Town & Country Planning Act 1990 (as amended)
Town and Country Planning (Development Management Procedure) (England) Order 2015
Approval of details reserved by condition imposed under BR/236/24/PL relating to condition 4-surface water drainage scheme.
Bognor Regis Football Club Nyewood Lane Bognor Regis PO21 2TY

Arun District Council have decided to **REFUSE details reserved by condition for the following reasons:**

REVISIONS
PROPOSED DRAINAGE LAYOUT

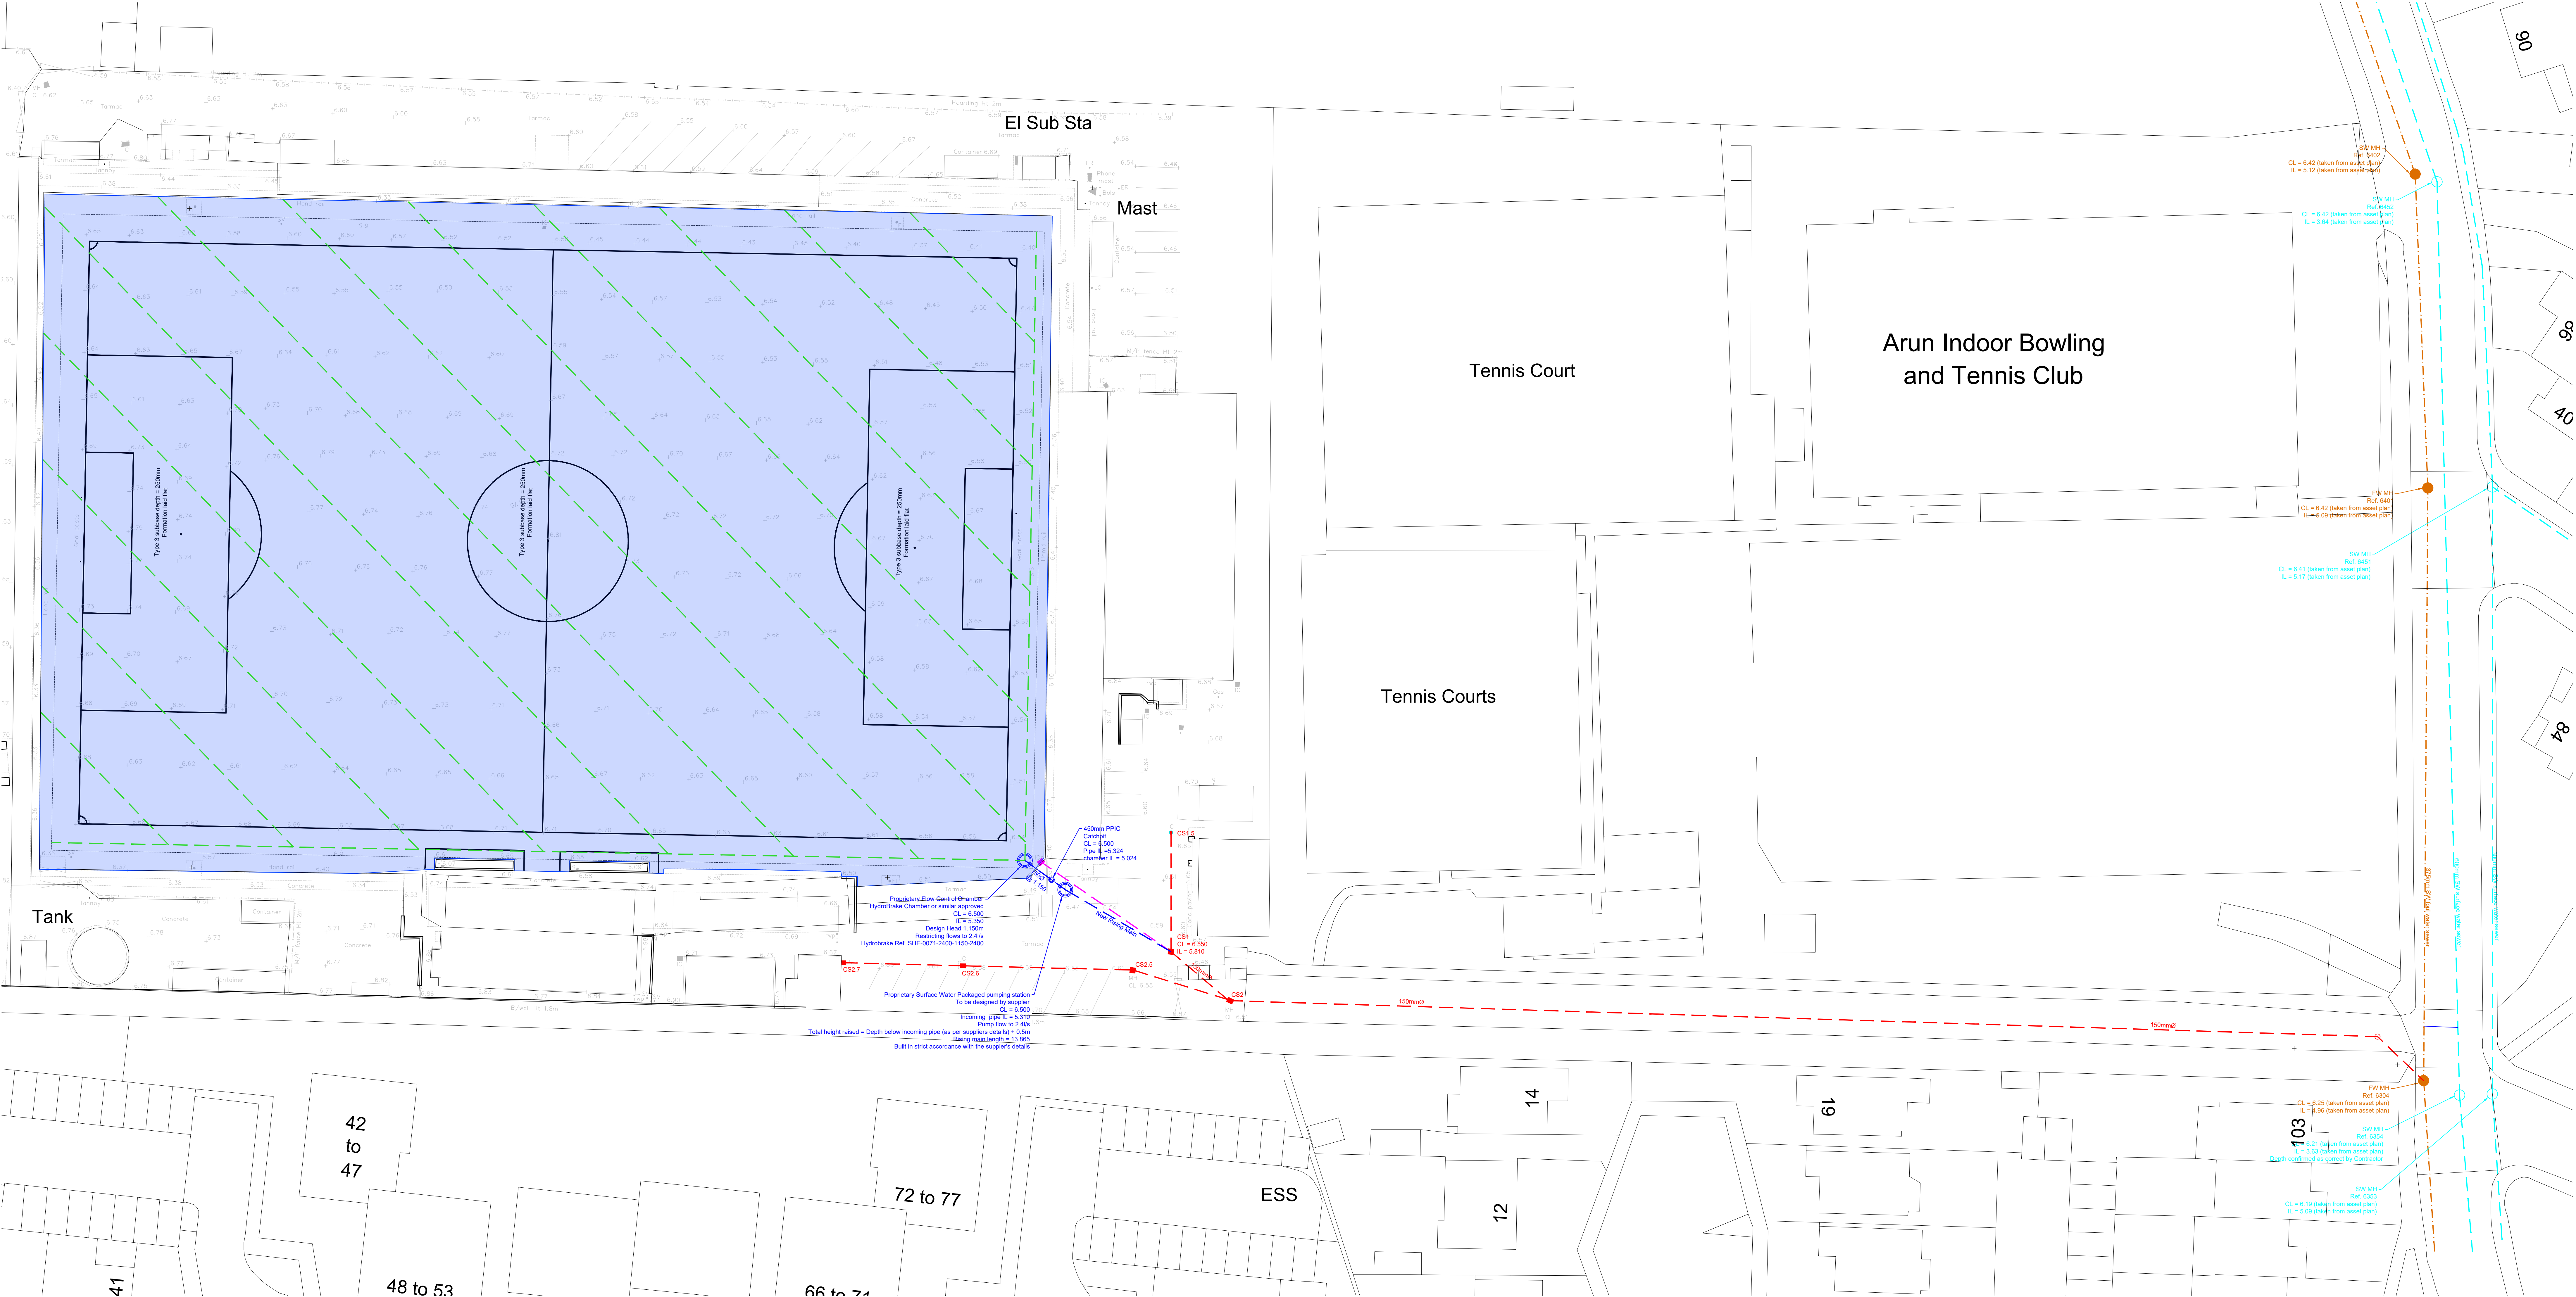
The council drainage engineers have objected to the discharge of the condition with the following comments. The current proposal is to discharge (via pumping) surface water runoff from the football pitch into the foul sewer network. The NSfS does not consider discharges of surface water to foul sewer networks as a recognised option. The proposals also intend to pump surface water rather than to use gravity.

The information submitted is not adequate to discharge the condition as the connection proposed is not a recognised disposal location in the National Standards for SuDS.
